Current Zoning: MUDD-O (mixed use development district, optional) and N1-A (neighborhood 1, A)  
Proposed Zoning: RAC(CD) (regional activity center, conditional)

Approximately 2.28 acres located on the east side of Apex Drive and north side of Coltsgate Road, west of Cameron Valley Parkway.

The petition proposes a multi-family residential development as part of the Apex Southpark project on parcels currently developed with surface parking and one single family home.

Staff recommends approval of this petition.

TECHNICAL DATA SHEET

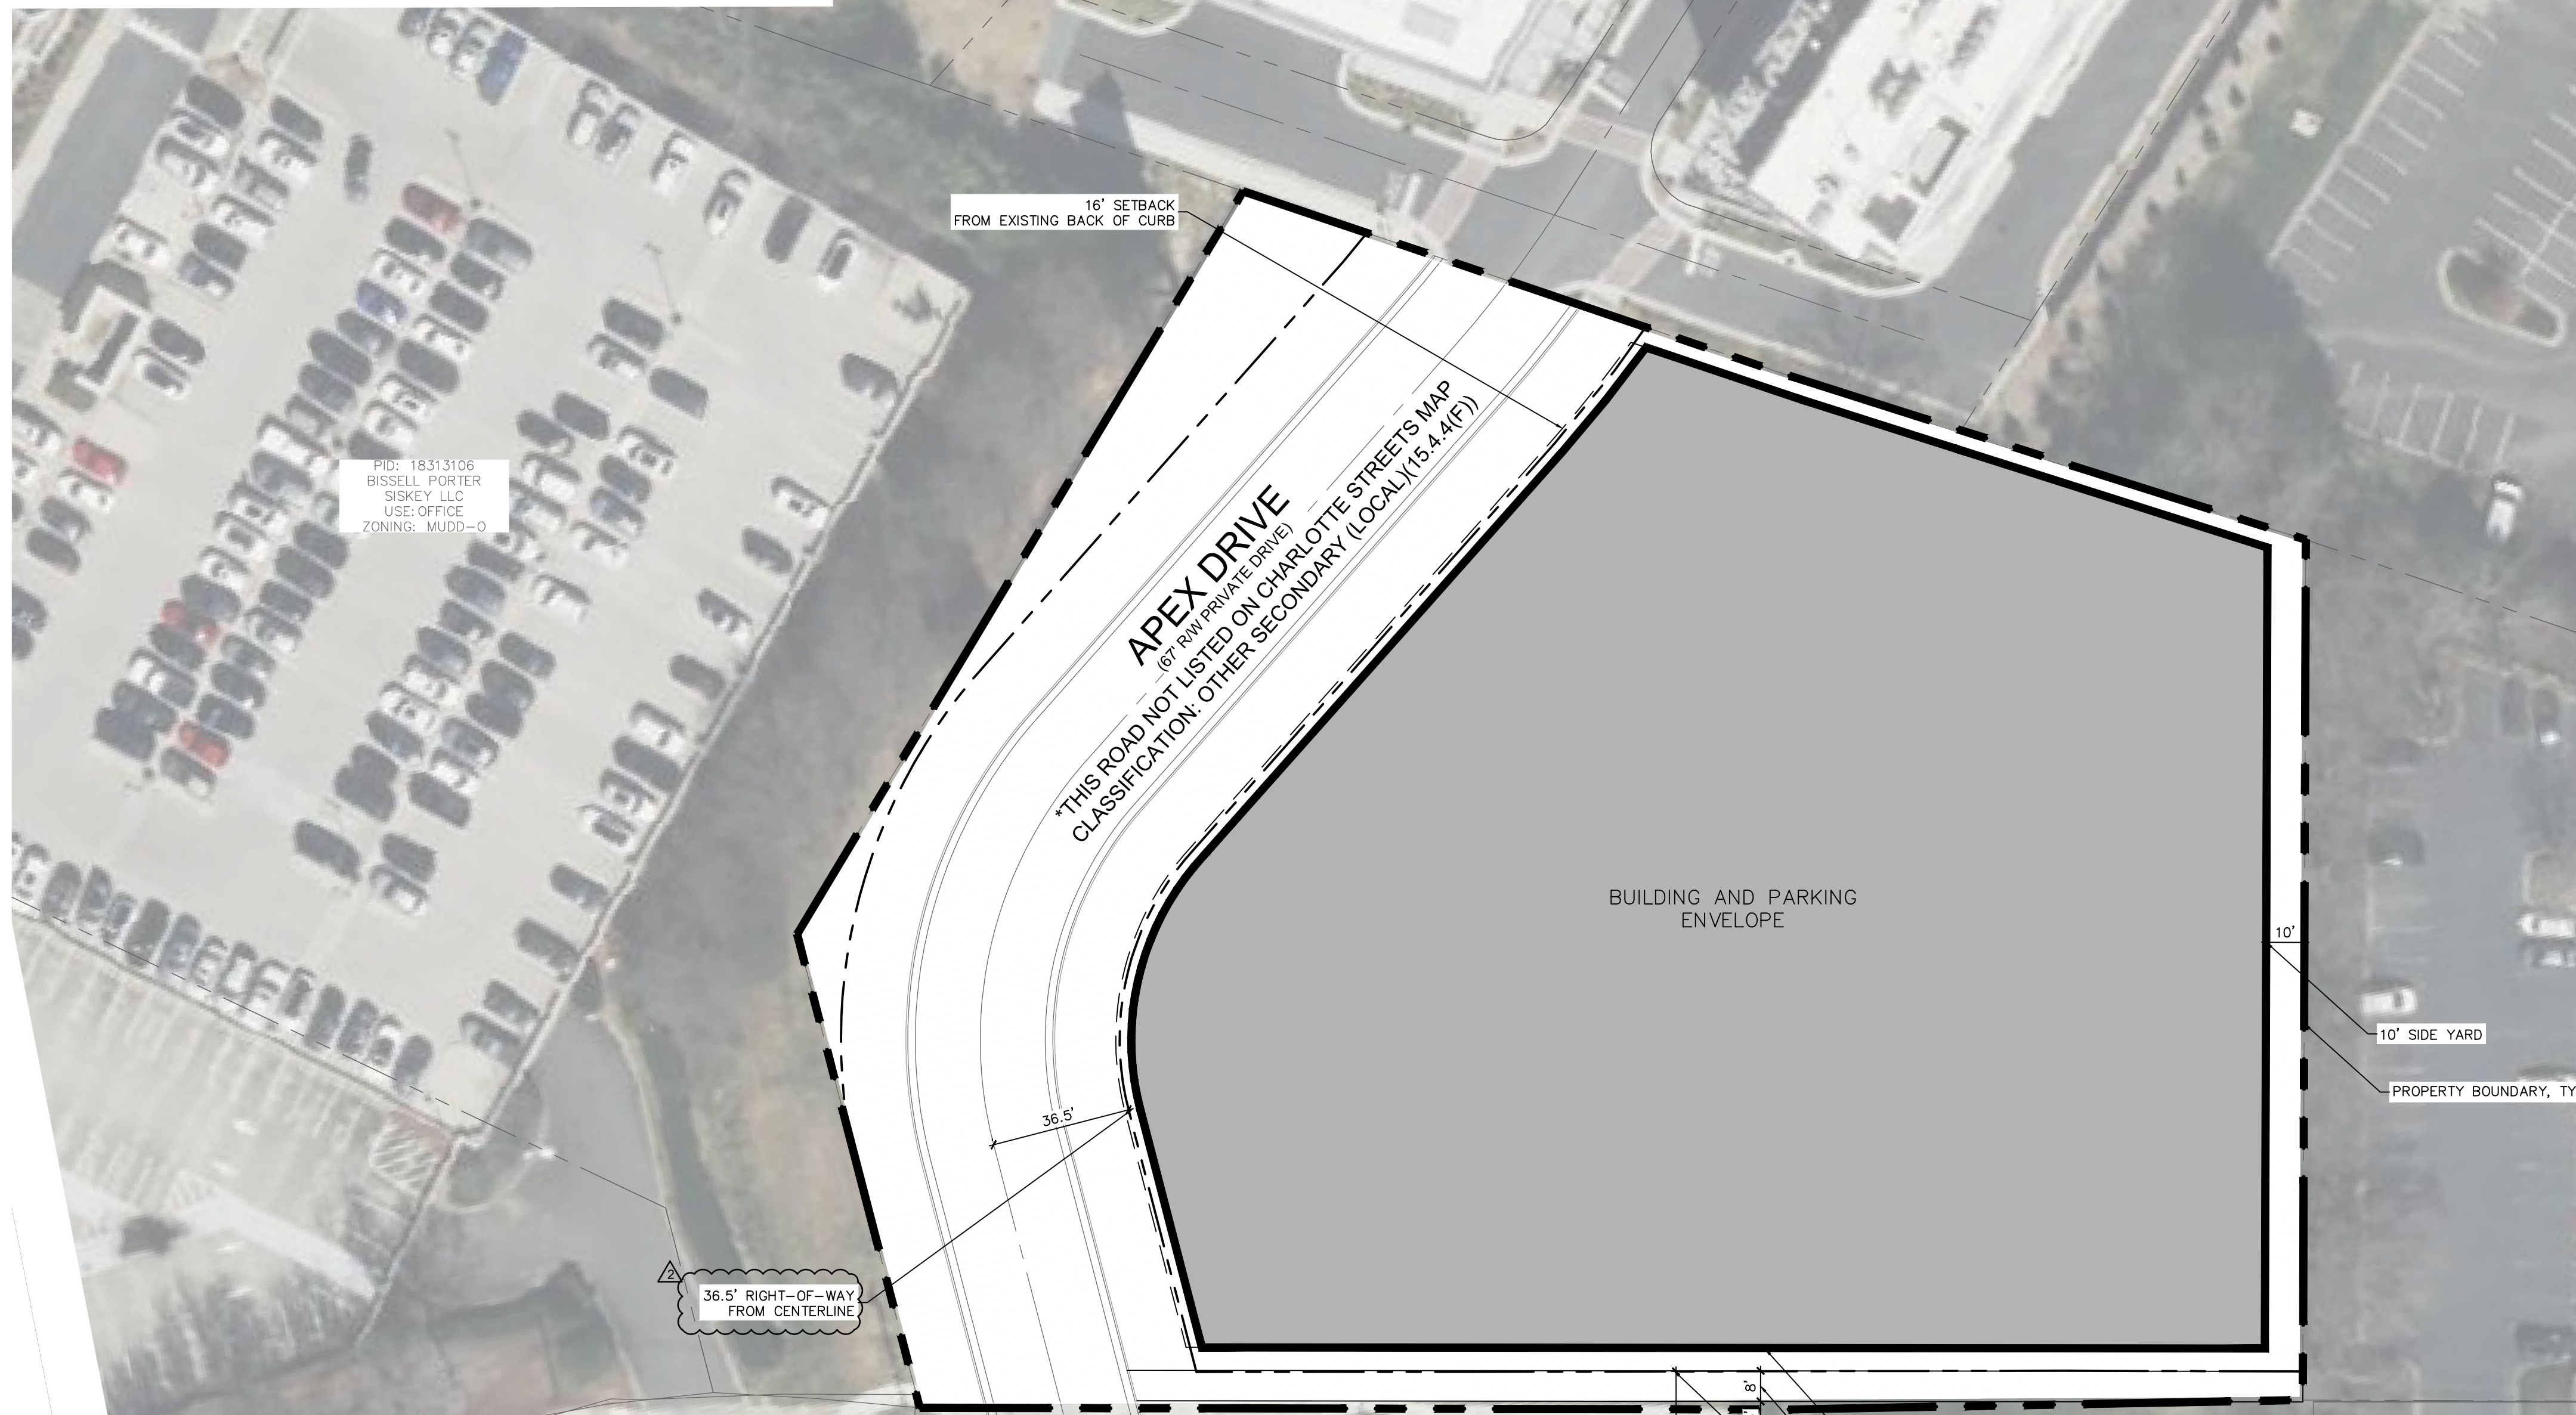
2. ~~Add a note specifying that any height above 150' will be achieved utilizing development bonus standards outlined in Article 16 of the UDO.~~ **Addressed**

3. ~~Revise Note 1. of the Storm Water Quality Treatment conditions to specify 24% rather than 25%.~~ **Addressed**
